22 April 2016

**Modification Application under Section 96(1a) to SSD_6848 Stage 3B
Redevelopment Of Lismore Base Hospital, Lismore**

PROJECT NUMBER	DIRECTOR	CHECKED
3351L101	PT	
DRAWING NUMBER	REVISION	
ACD2003	M

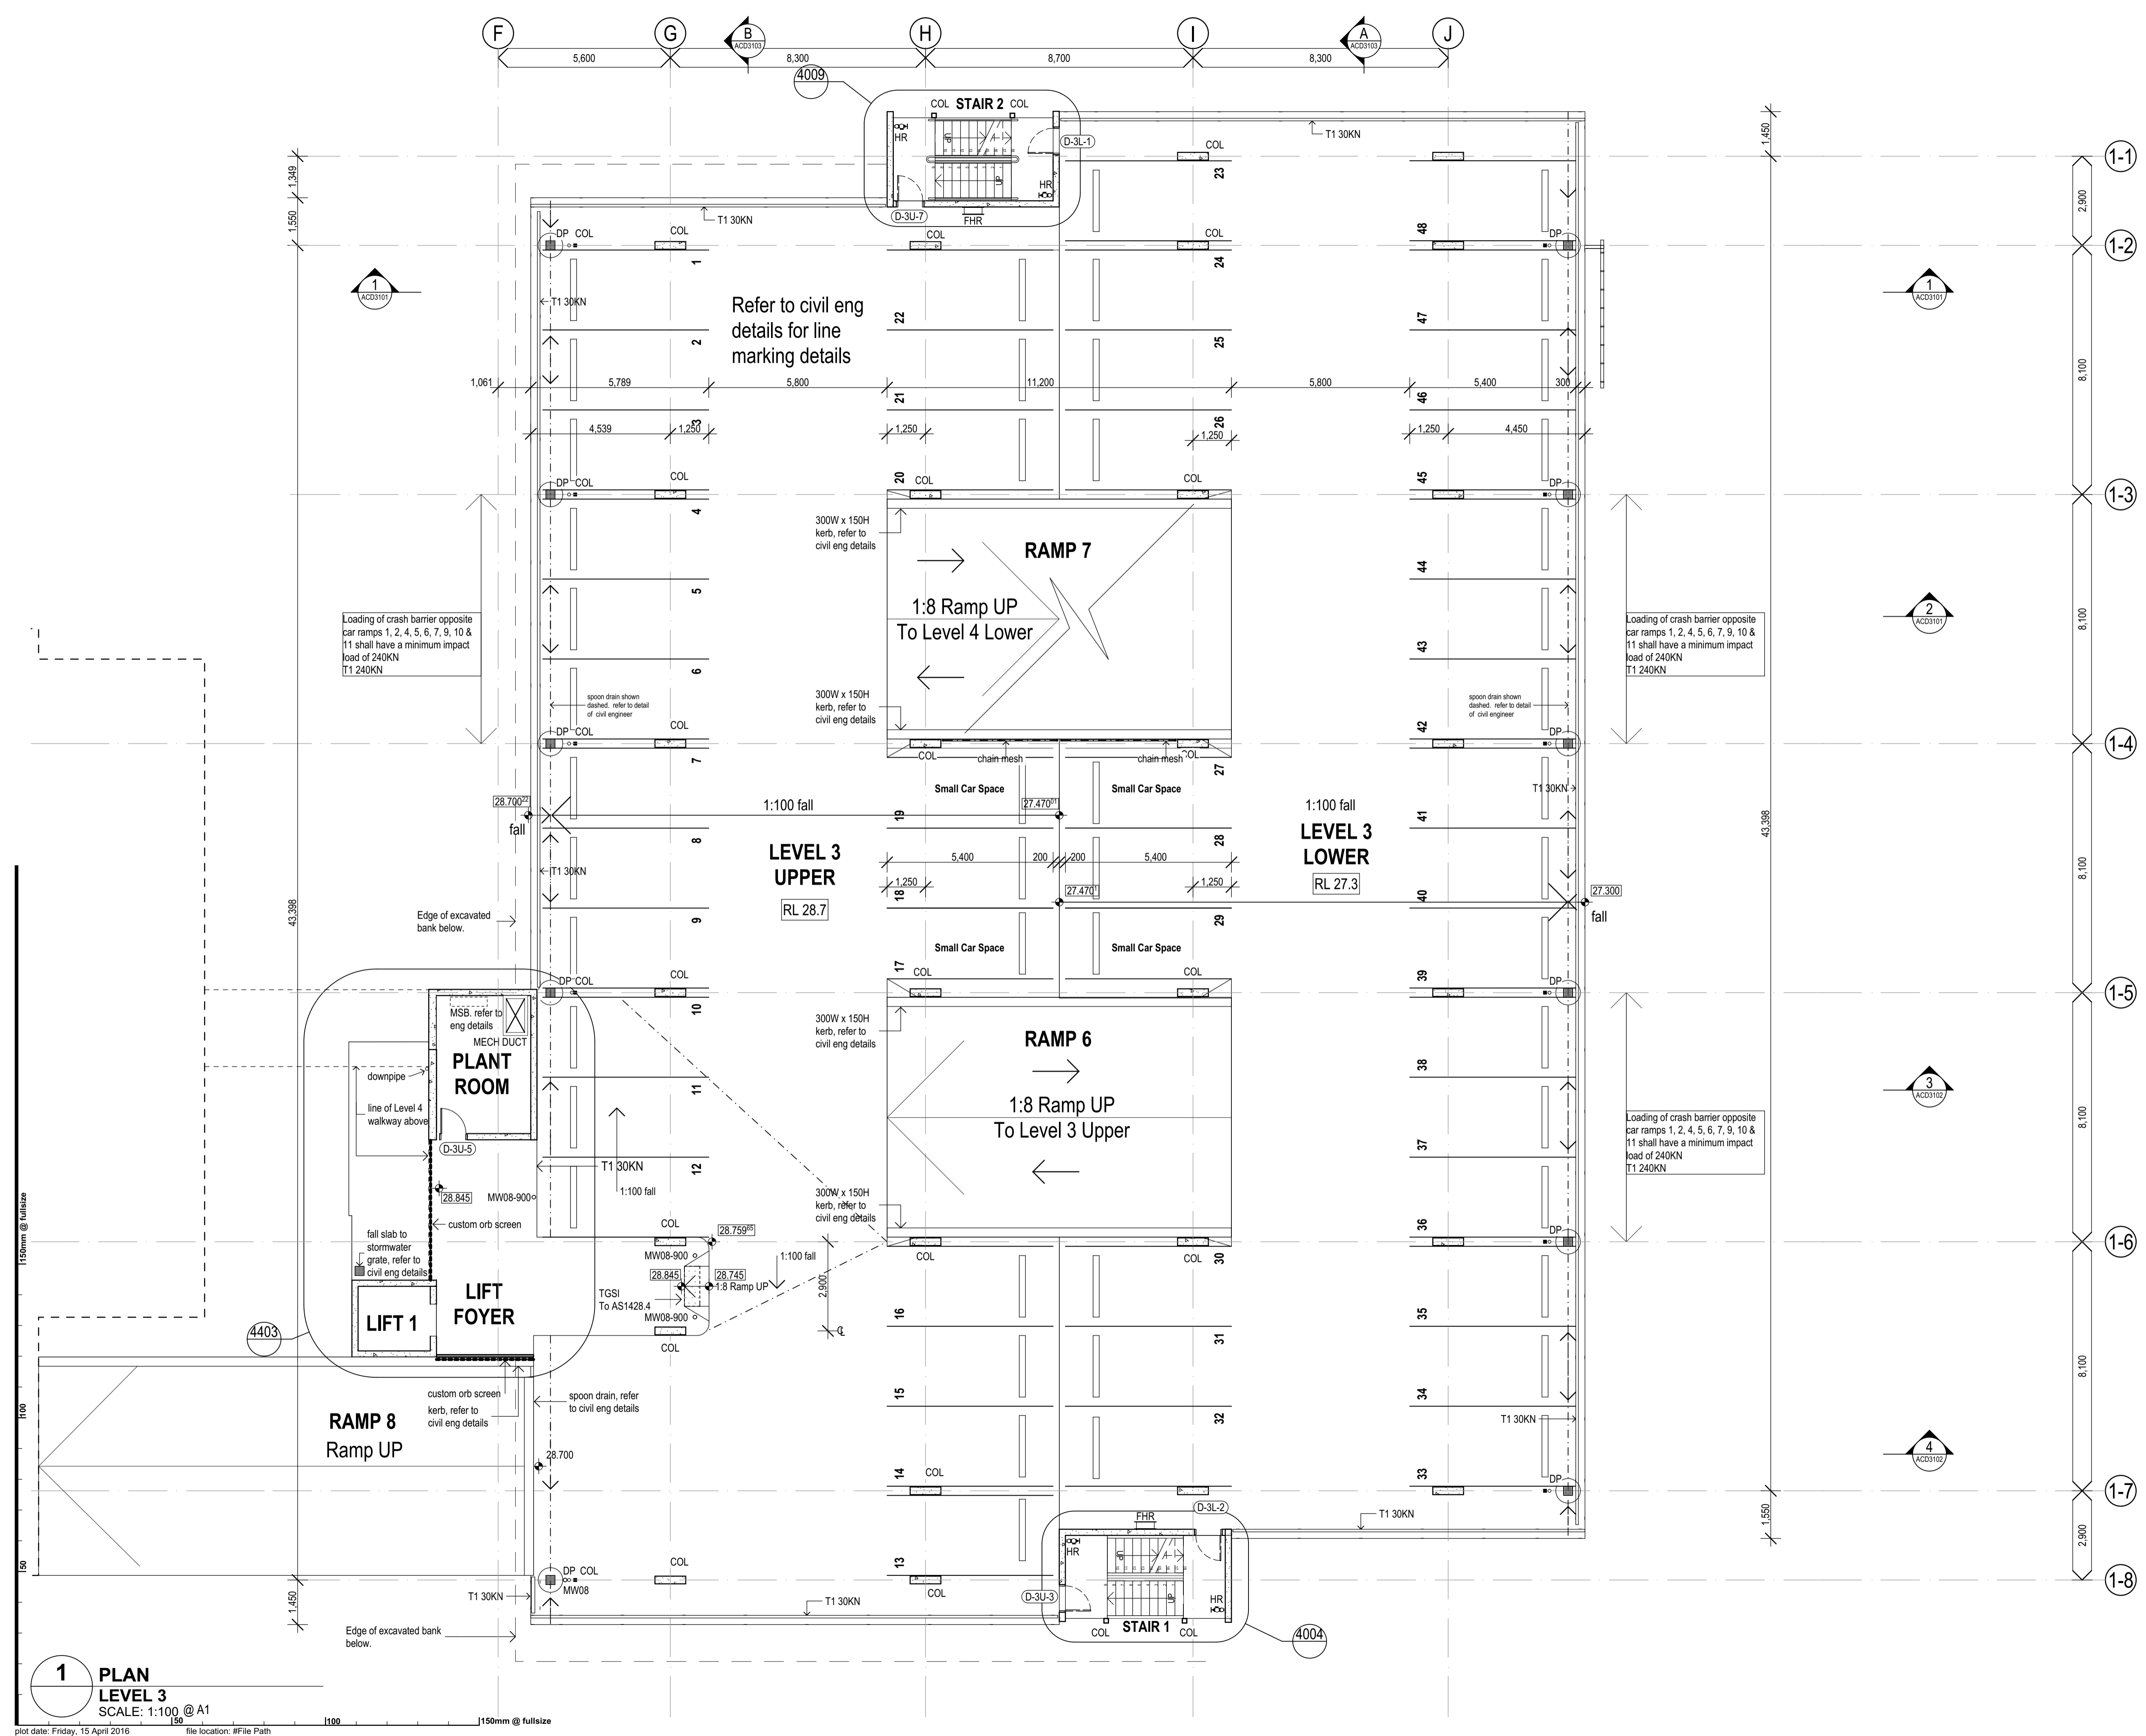
- A small additional section of façade screen has been added immediately to the west of the driveway where it enters Level 3; and
- General changes are proposed to the design of the façades, with the main changes related to the extent of black "guttering" that separates the coloured perforated screen, particularly on the southern elevation.

1 ELEVATION North
 SCALE: 1:100

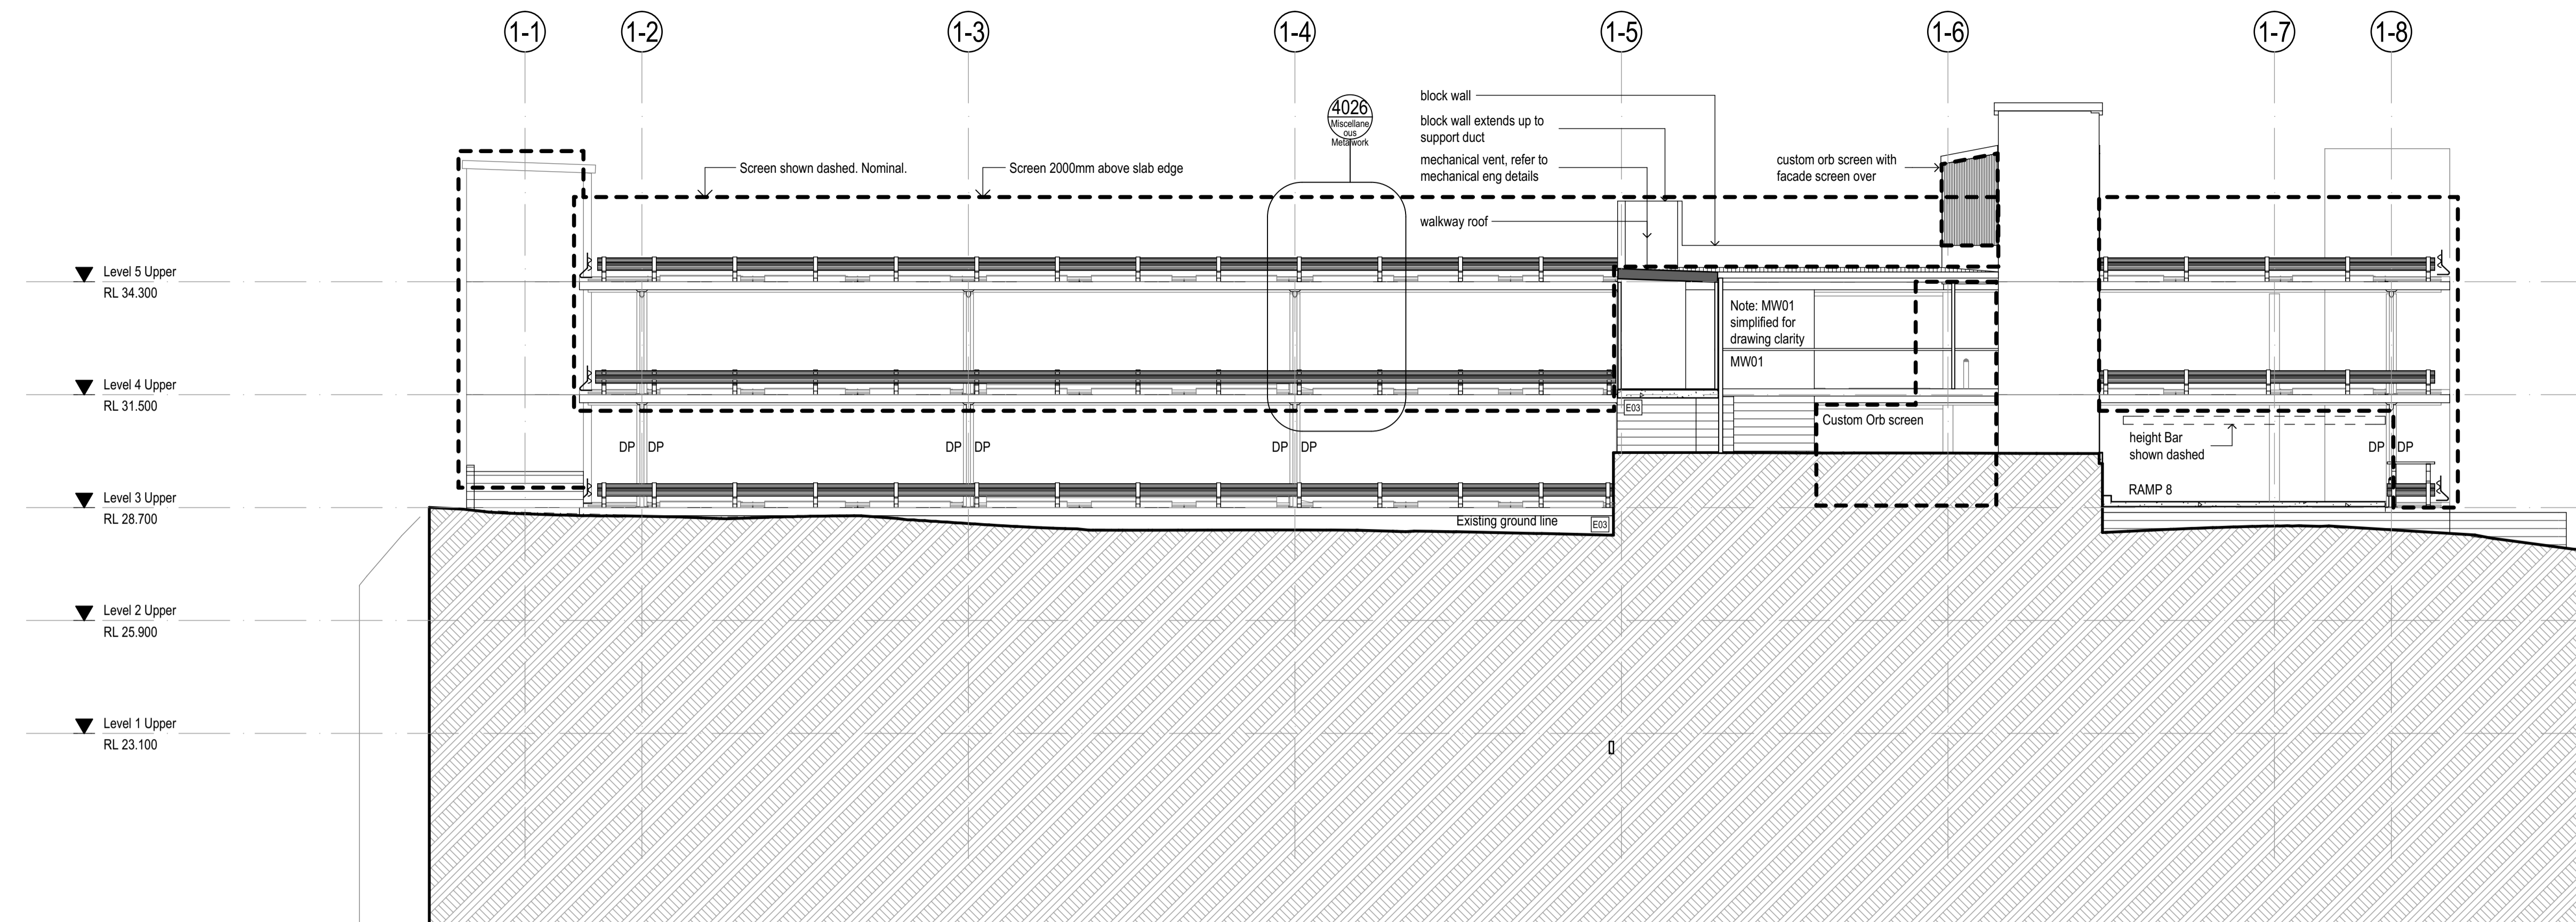
- A custom orb screen is proposed from the Level 3 slab to the underside of the Level 4 covered walkway roof for waterproofing purposes on the northern elevation (immediately to the east of the lift shaft);

2 ELEVATION
 West
 SCALE: 1:100

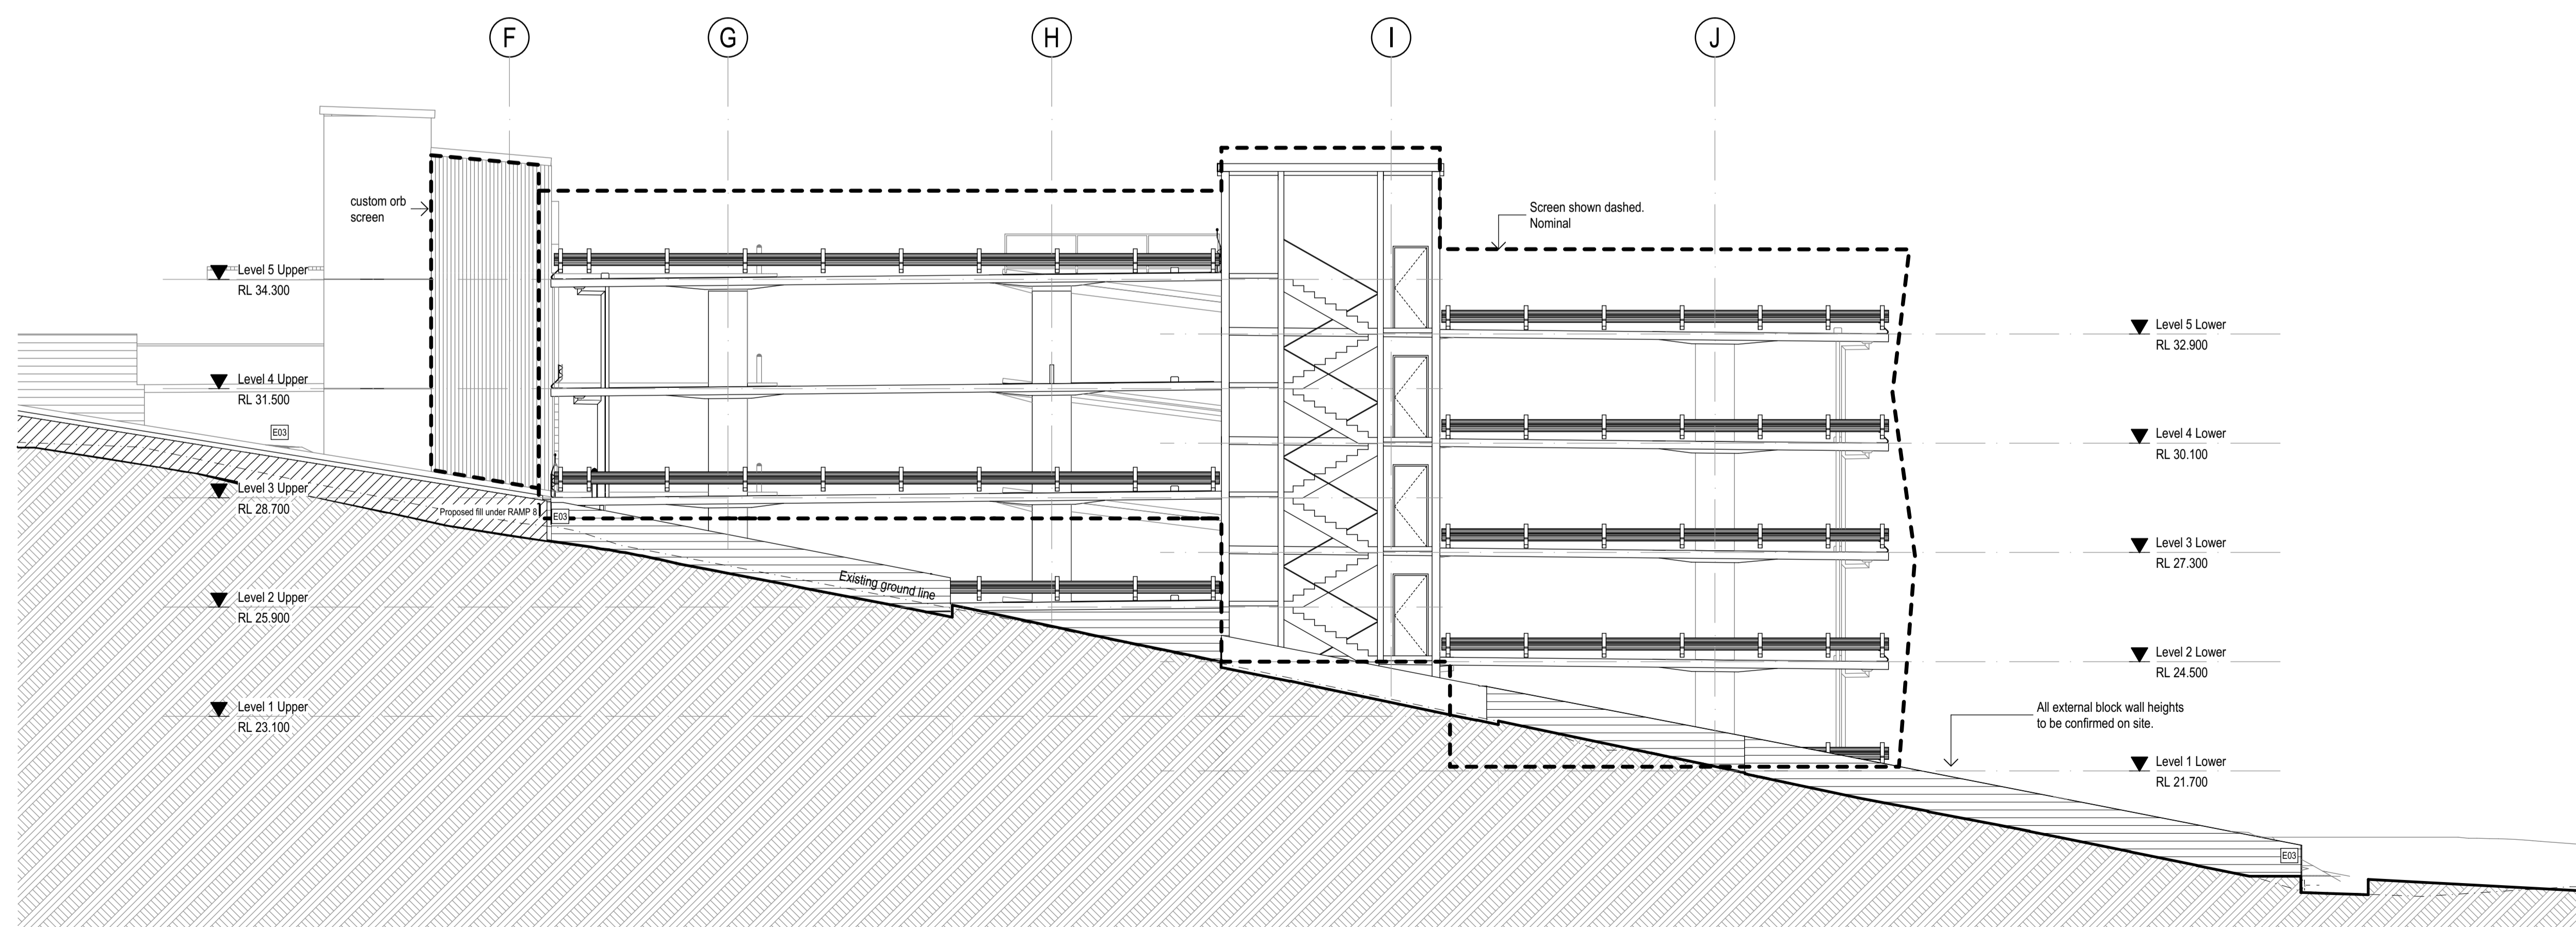
- A vertical colourbond custom orb screen is proposed to the full extent of the western elevation between the lift shaft & the northern façade, from the underside of the lift lobby roof on Level 5 to the point where the lift shaft meets the driveway. It is proposed to delete the section of façade screen to the western elevation to the same area (only previously proposed to Levels 4 & 5);
